NC DEPARTMENT OF  
**HEALTH AND  
HUMAN SERVICES**

July 26, 2019

Subject: 141 Old Barn Way, Mason Point Subdivision Lot 46  
LHD Request for Review – Session Laws 2013-413 and 2014-120  
Project Number: 2019-238

Harnett County Department of Public Health Site Sketch

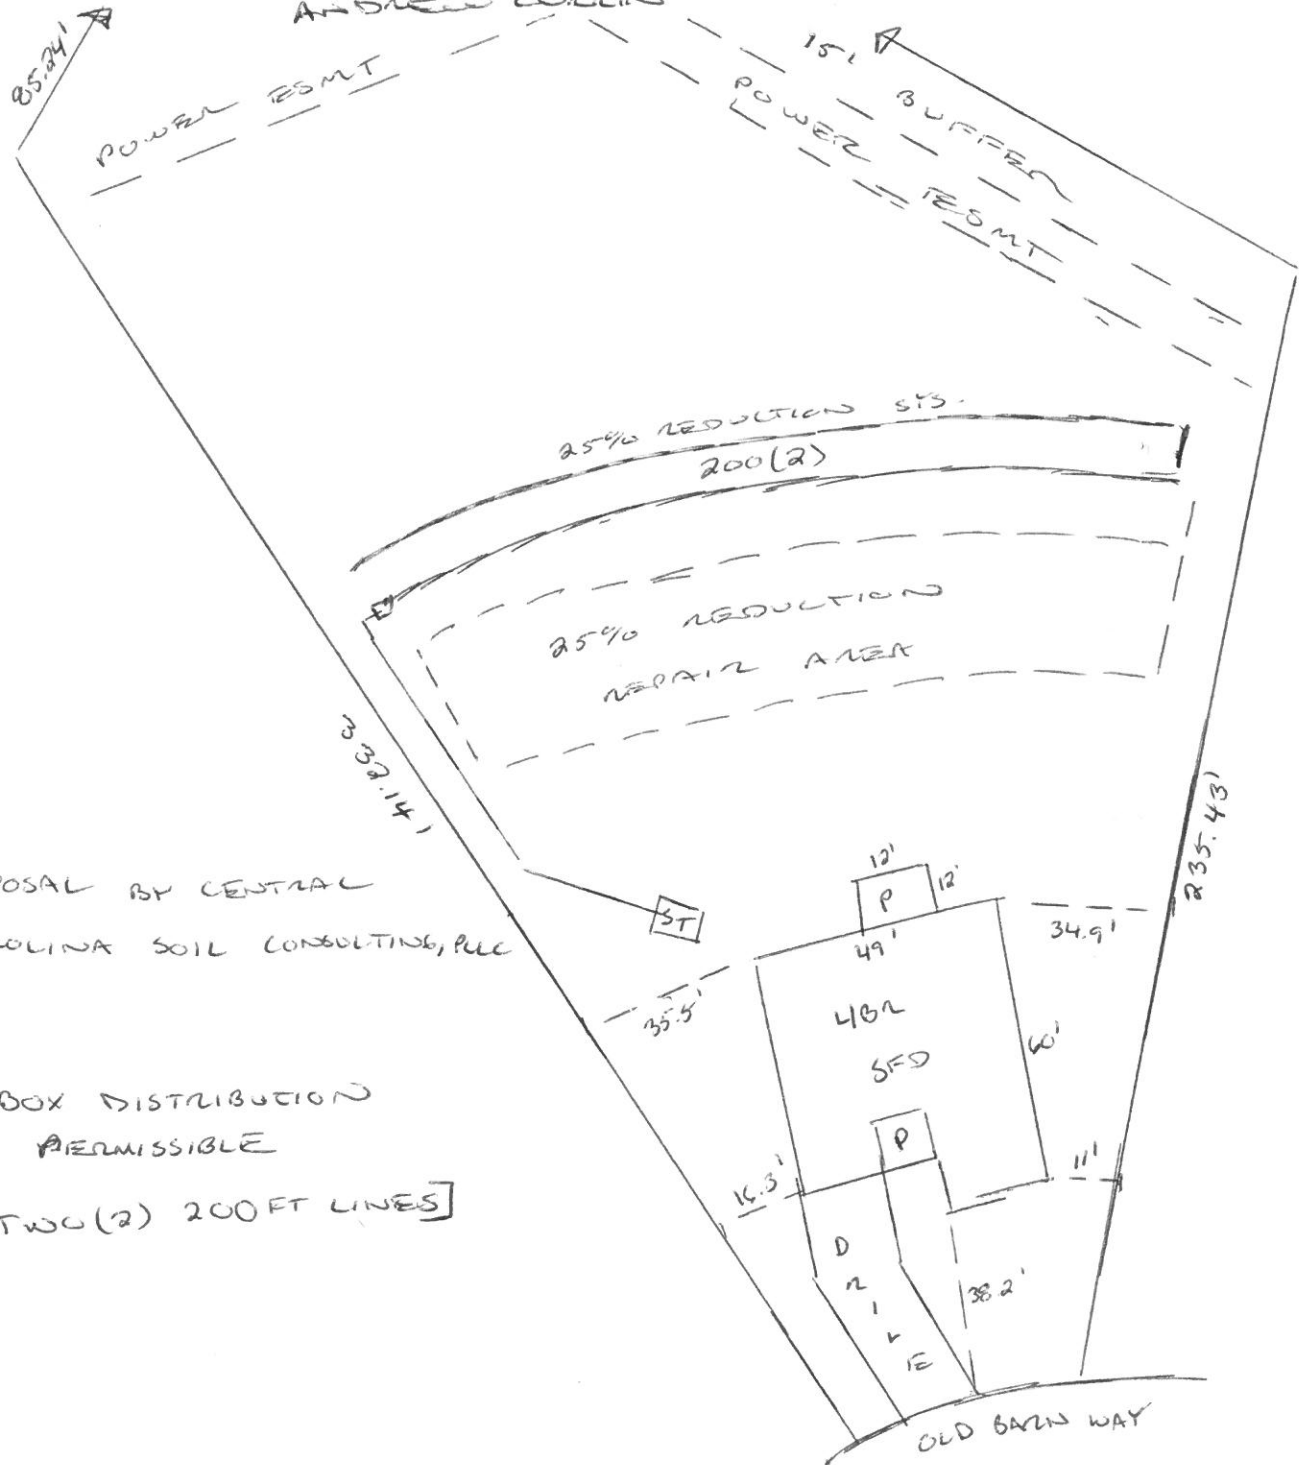
1. Due to the potential for wastewater effluent strength to increase with the proposed additional bedroom, have the PE conduct an evaluation of the proposed flow reduction/residence expansion to determine whether the reduction/expansion exceeds limits necessary to ensure wastewater system integrity and protect public health, safety, and welfare based on site specific conditions and provide a written determination to the Harnett County Health Department.
2. Tanks are to be sized based on unreduced DDF in accordance with 15A NCAC 18A .1952 and .1955(k). The septic tank capacity indicated on the Harnett County Department of Public Health Improvement Permit/

Construction Authorization application does not meet the requirements of the Rule and an increase in volumetric capacity of the pump tank may be required.
